September 27, 2012
09006

Level I Site Plan Application – Baxter Blvd Storage Conduit Utility Building and Trail Work

We reviewed Woodard & Curran's peer review comments for a Level 1 Site Plan Application in a memo to you on September 25, 2012. We offer the following responses (in bold) to Woodard & Curran's comments:

**BAXTER BOULEVARD
 NORTH STORAGE CONDUIT
 OVERALL
 DESIGN PLAN**

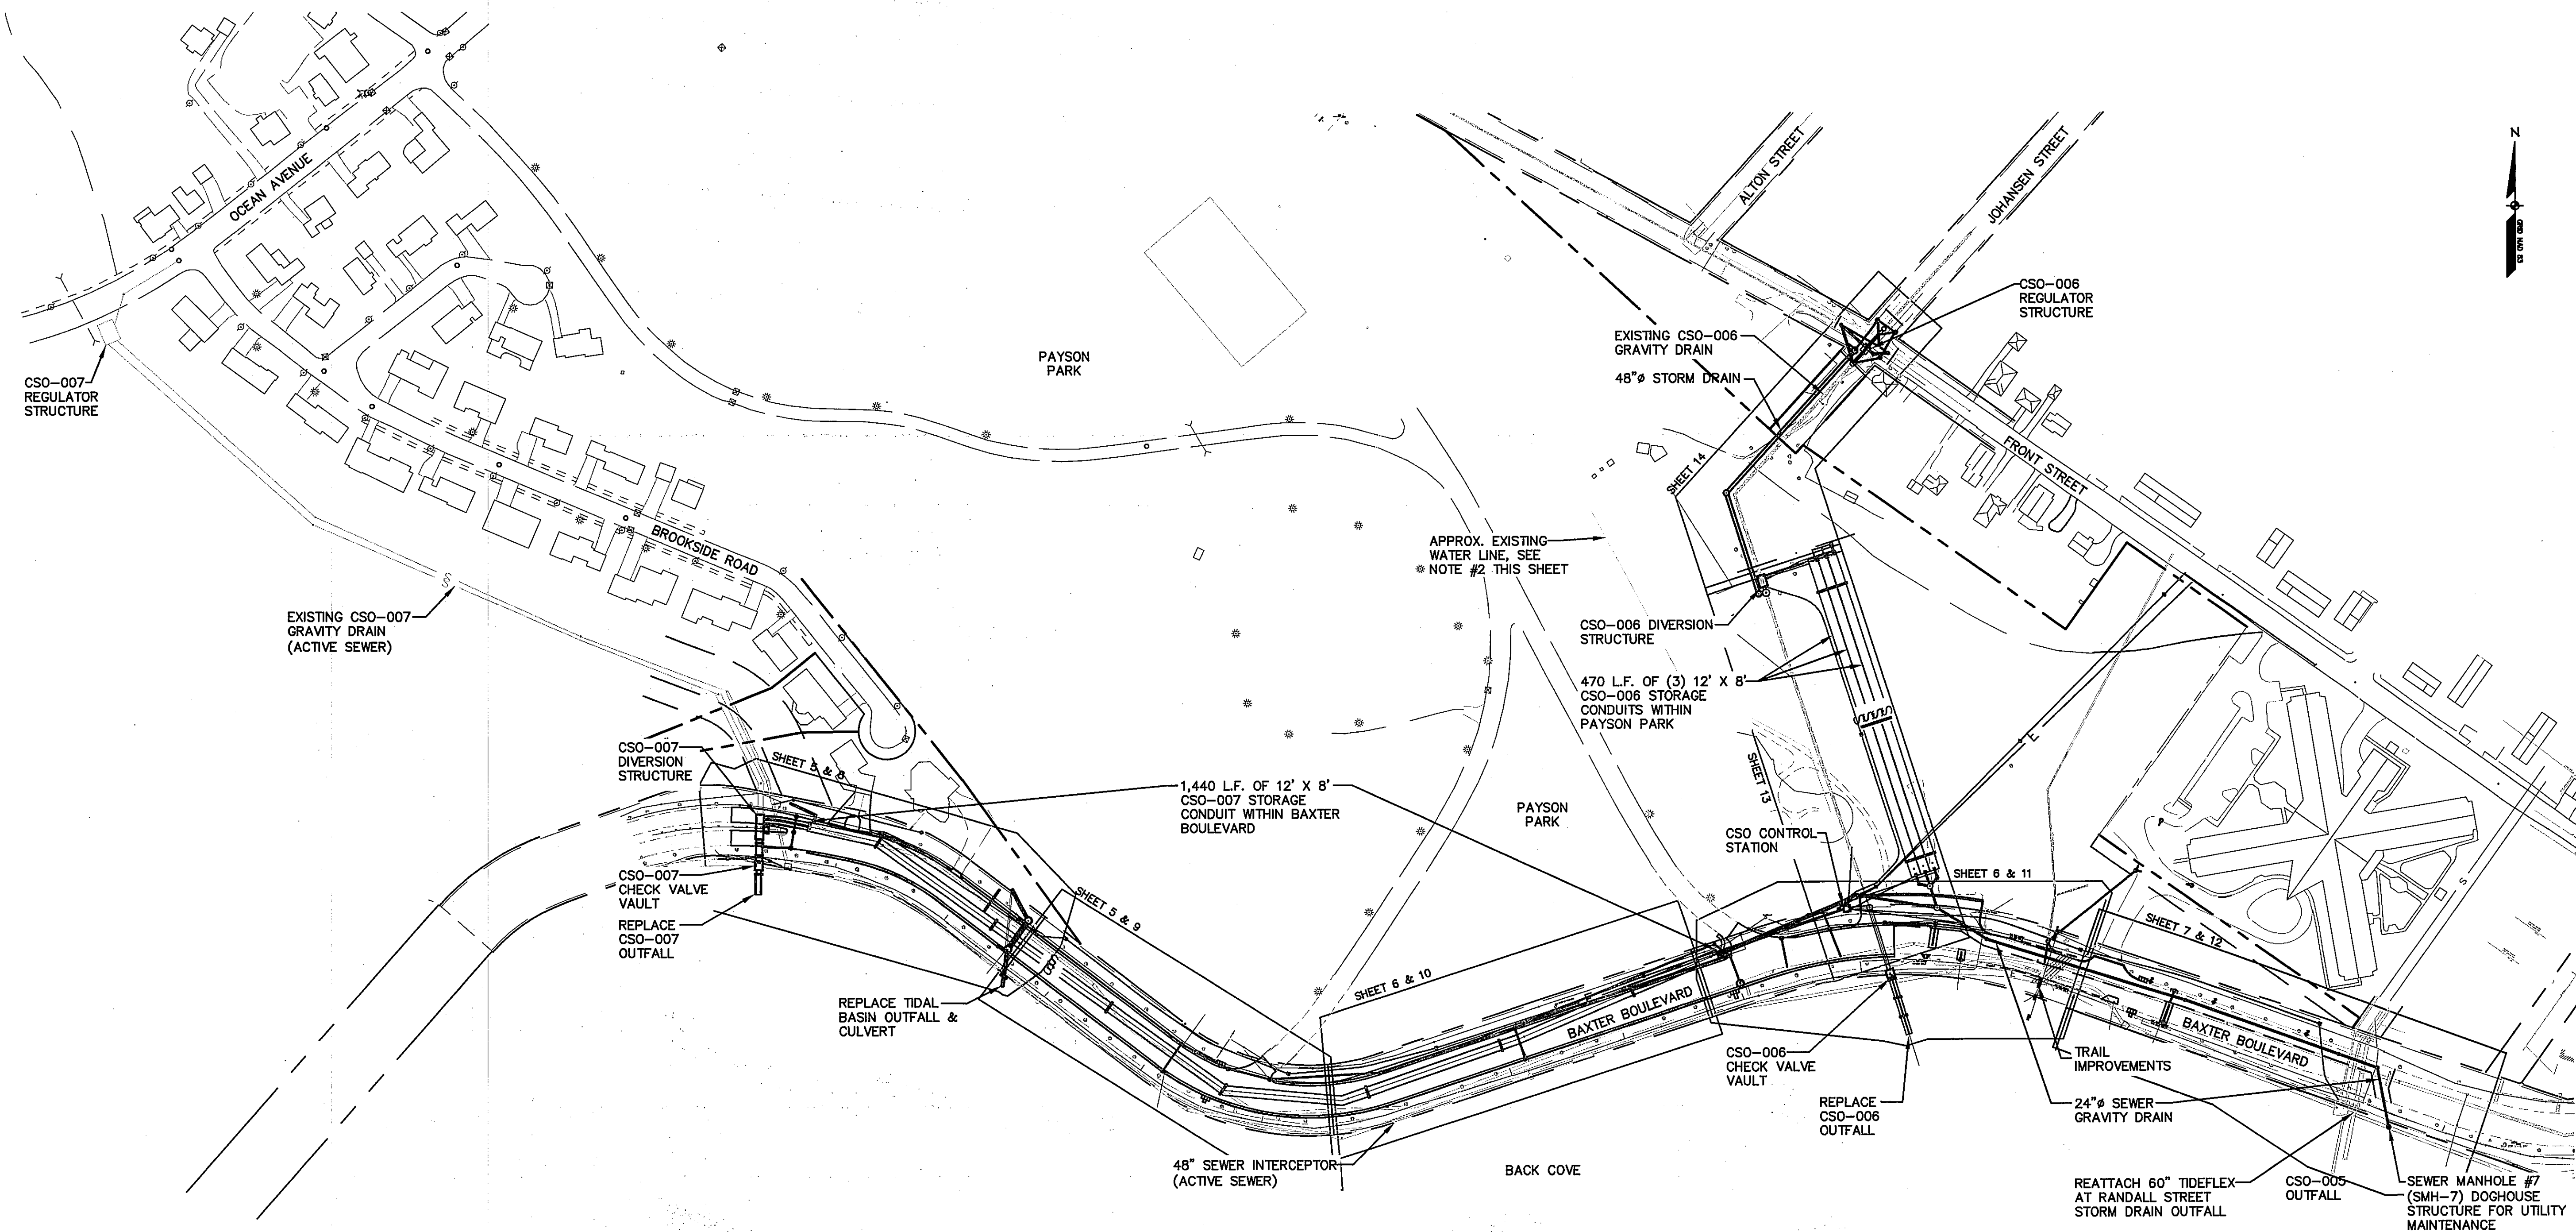
- 2) The Applicant should provide design details for the work (trail section, slope stabilization details, erosion control details).

Sheet 27 (enclosed) shows a typical trail section. Riprap slope stabilization details and construction notes, erosion control details for stabilized construction entrance, silt sack, silt fence and erosion control blanket installation, are all shown on Sheet 26. In addition, we have enclosed an Overall Design Plan that shows the riprap slope and CSO control station in relationship to the entire project for reducing Combined Sewer Overflows ("CSO's"). Please note the riprap slope is shown as "trail improvements" on the Overall Design Plan.
